SHOALHAVEN CITY COUNCIL
ENVIRONMENTAL ASSESSMENT SUBMISSION TO THE NSW DEPARTMENT
OF PLANNING PART 3A, ENVIRONMENTAL PLANNING & ASSESSMENT ACT, 1979

MAJOR PROJECT APPLICATION MP 06_0205

Vincentia District Centre
Modification No 5

PROPOSAL: Proposed MP06_0205 VDC Stage 1 - Modification No 5 being a modification to the VDC Stage 1 approvals issued in Modifications 2, 3, and 4.
Delivery of the VDC in two stages with an amended floor layout design and Statement of Commitments and proposals for a fuel and fast food outlet in Stage 1.

NOTE:
SKETCH PLAN ONLY. PROPERTY BOUNDARIES,
UTILITIES, KERBLINES & DIMENSIONS ARE SUBJECT TO
SURVEY AND FINAL DESIGN. TRAFFIC MEASURES
PROPOSED IN THIS PLAN ARE CONCEPT ONLY AND
ARE SUBJECT TO FINAL DESIGN BY CIVIL ENGINEERS.

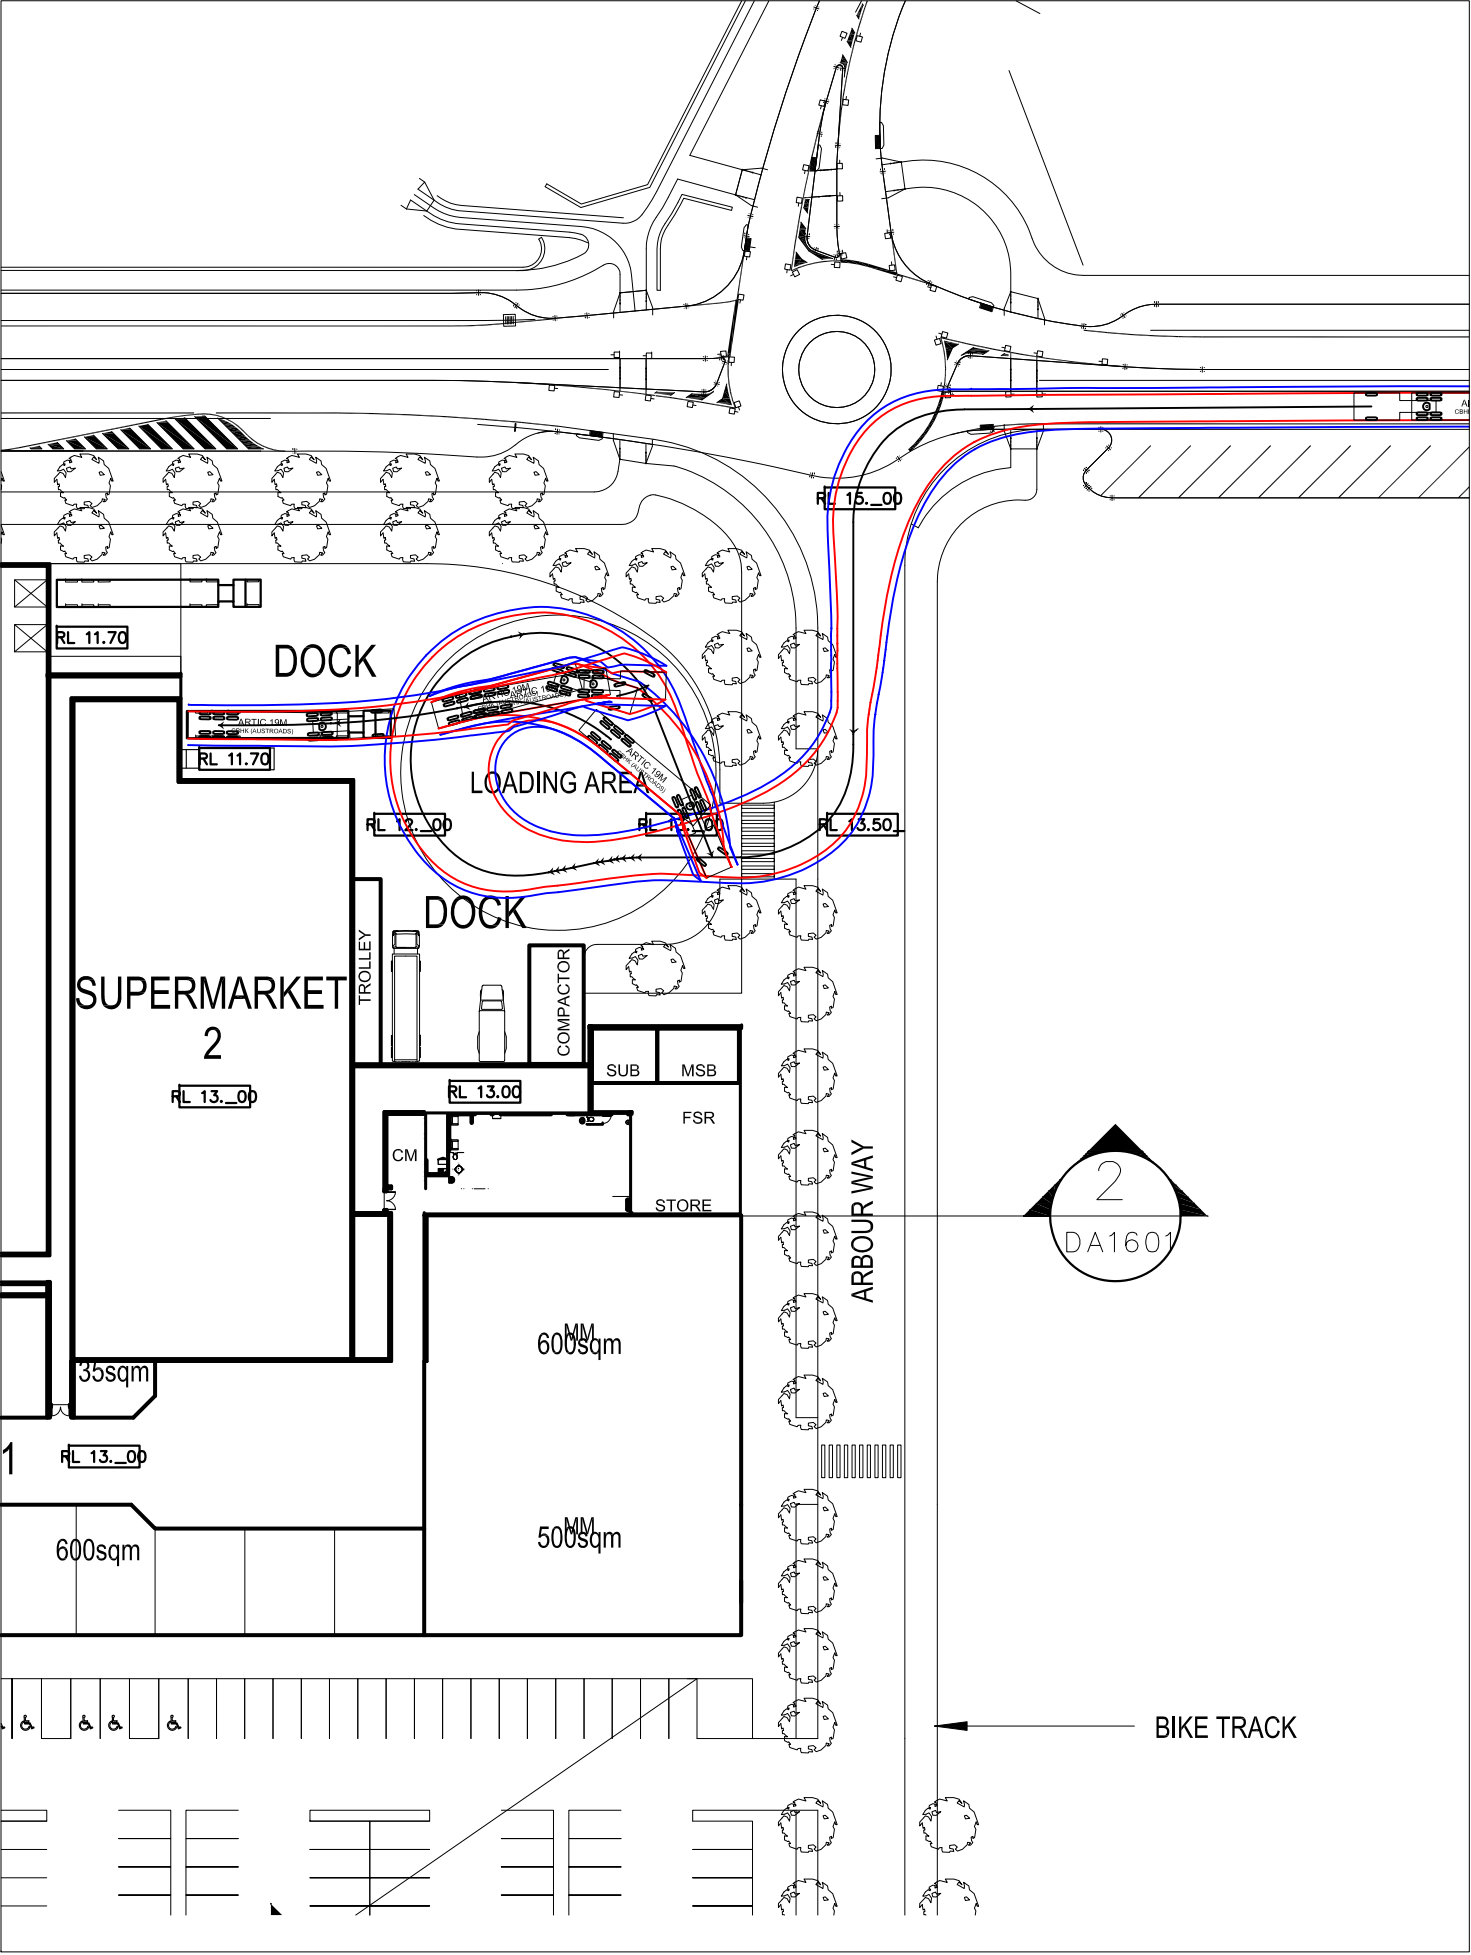
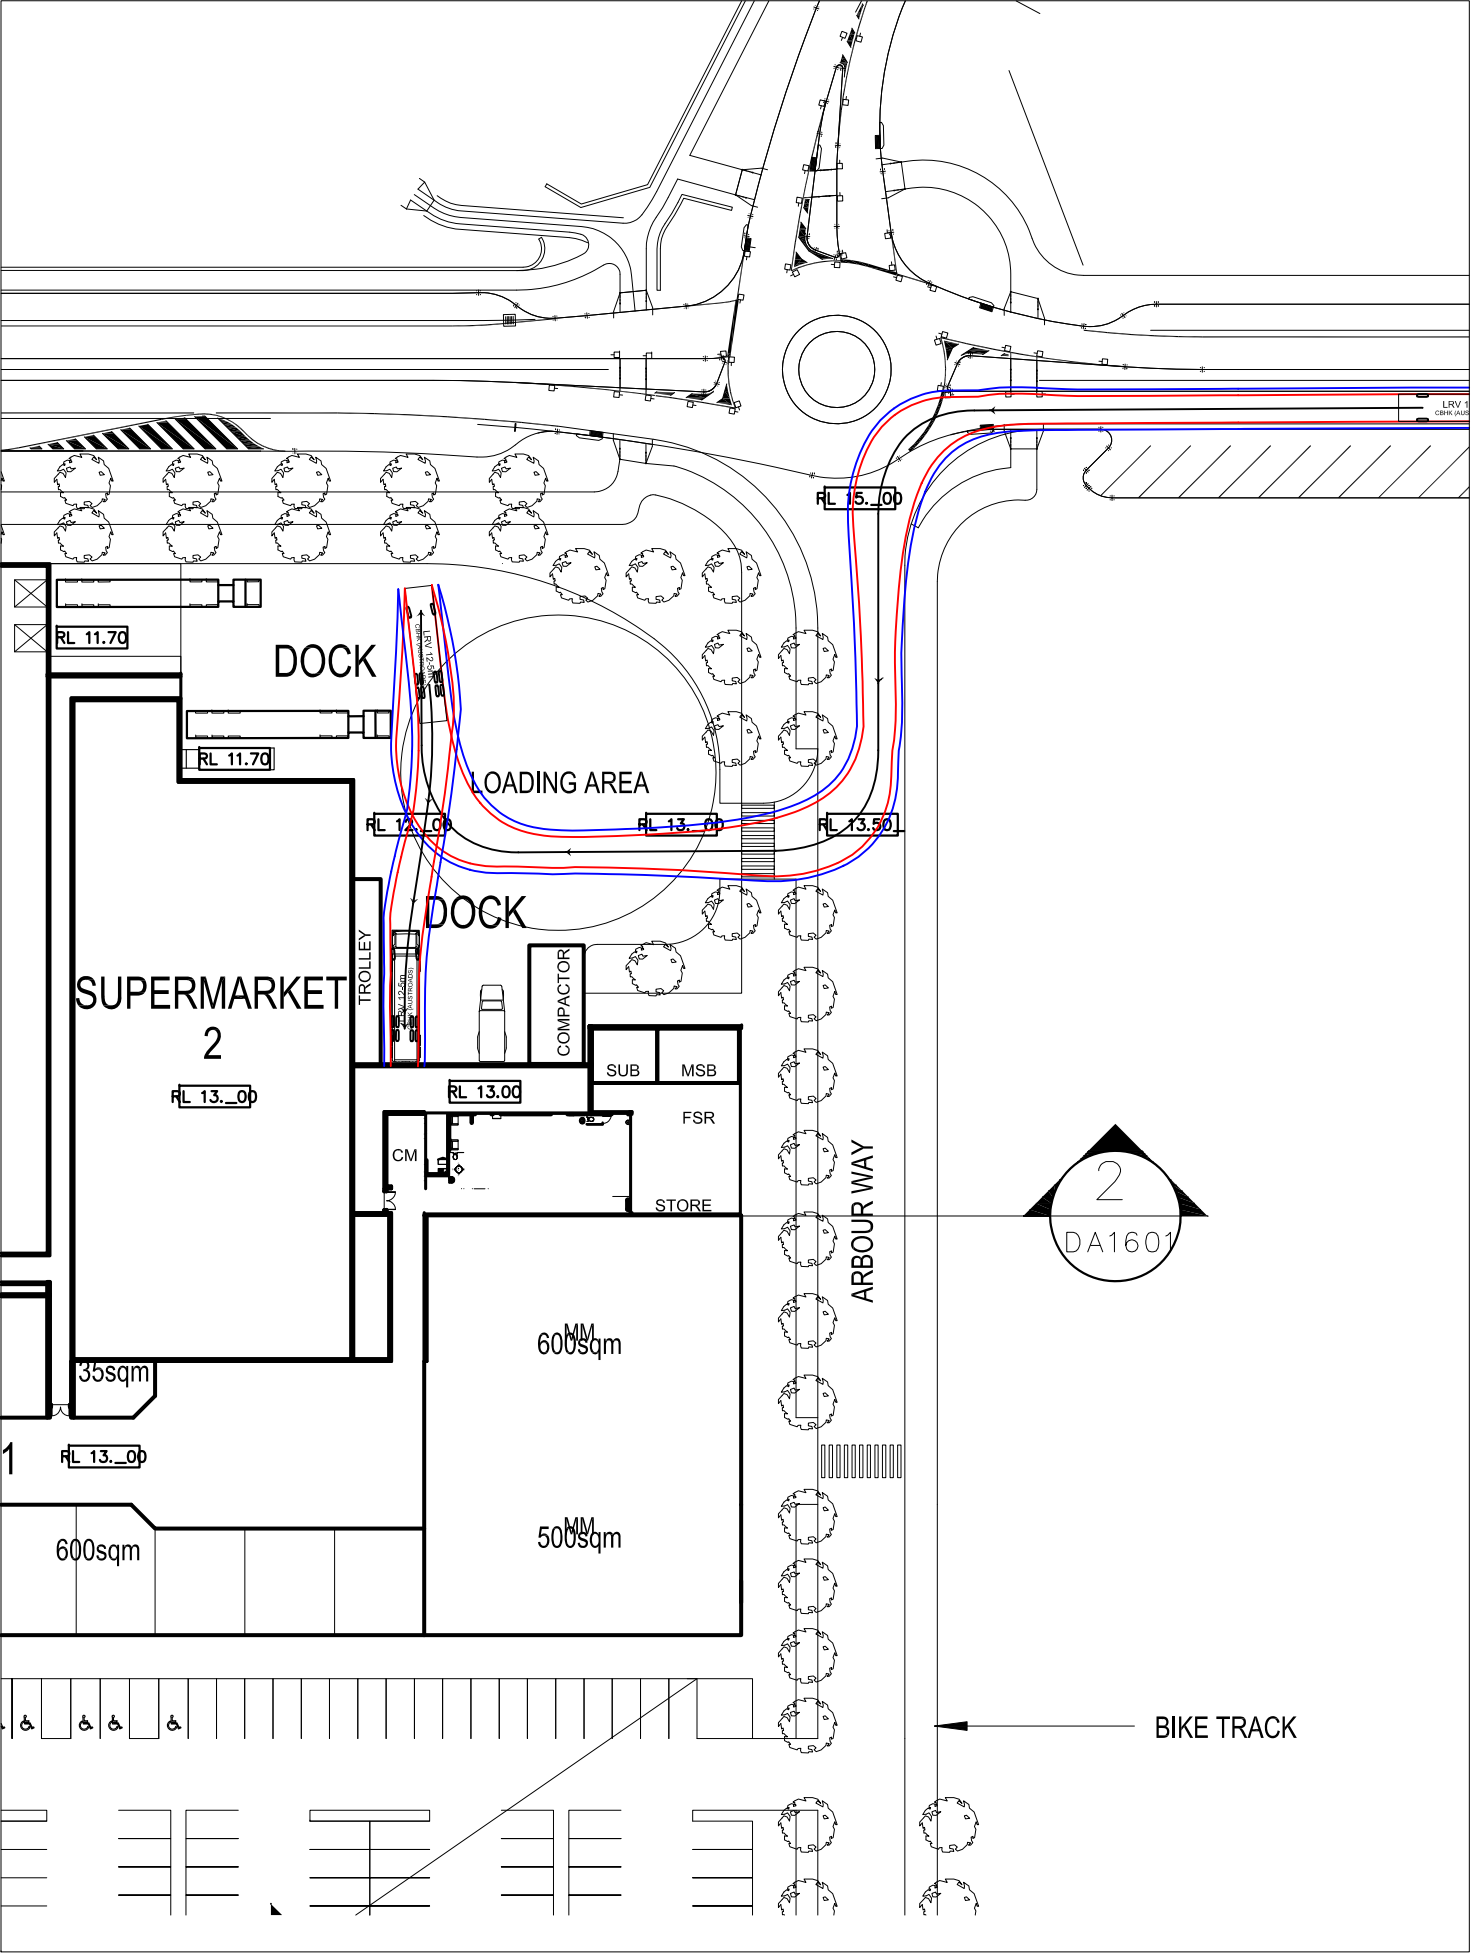
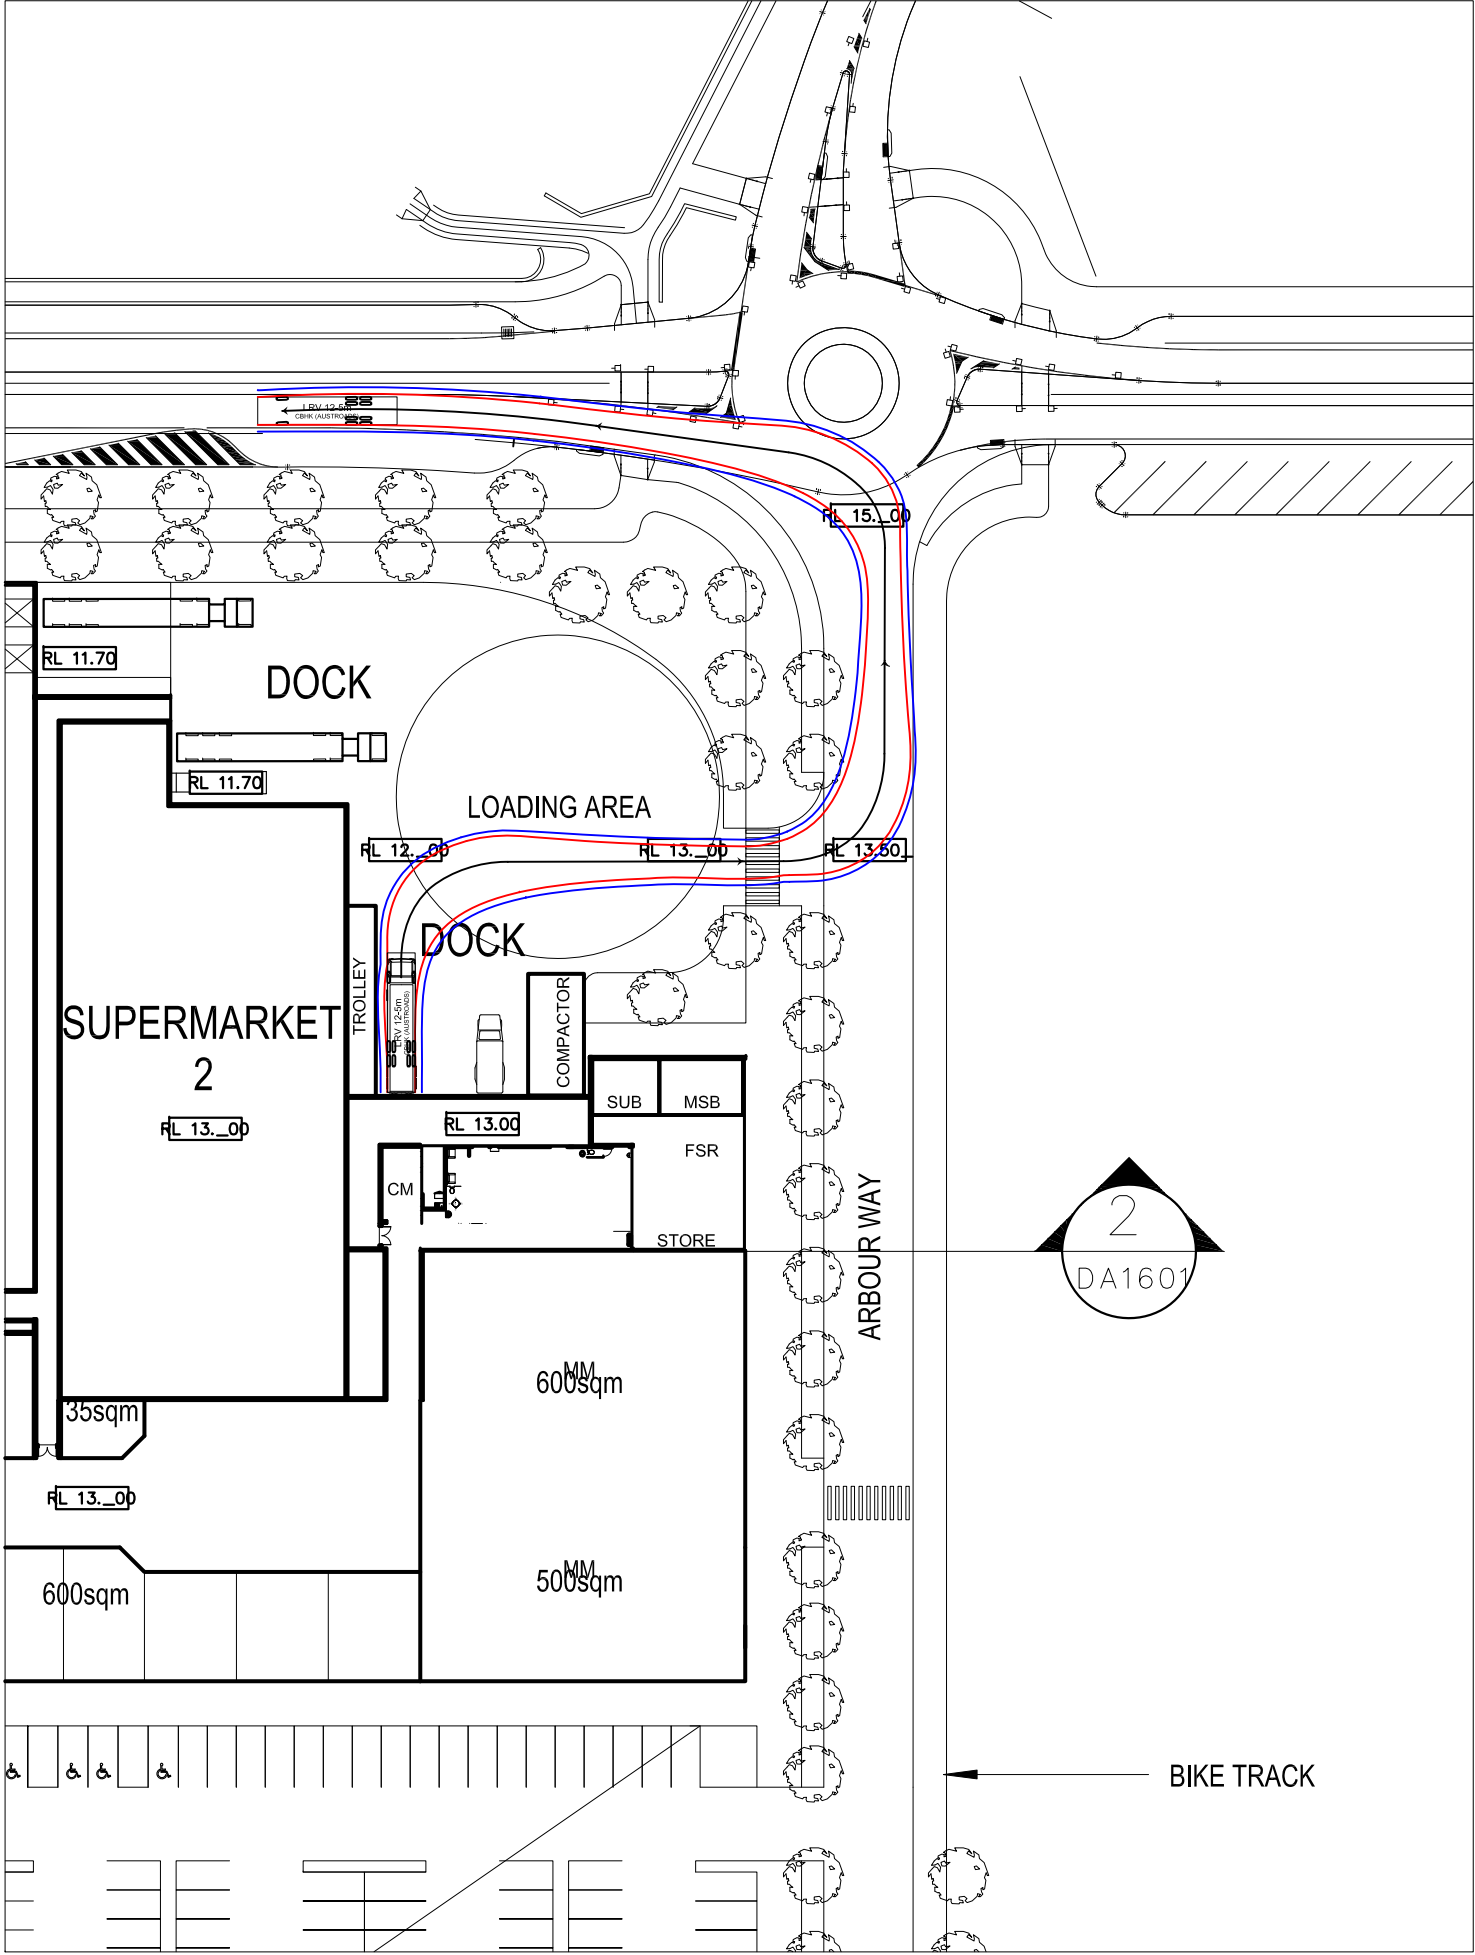
The Colston Budd Hunt & Kafes Pty Ltd (CBHK) Stage 1 report includes vehicle swept paths for the Stage 1 loading dock. However, the CBHK Stage 2 report does not include swept paths for the two loading docks for the retail and bulky goods buildings and this will be required to validate the practical use of the loading docks.
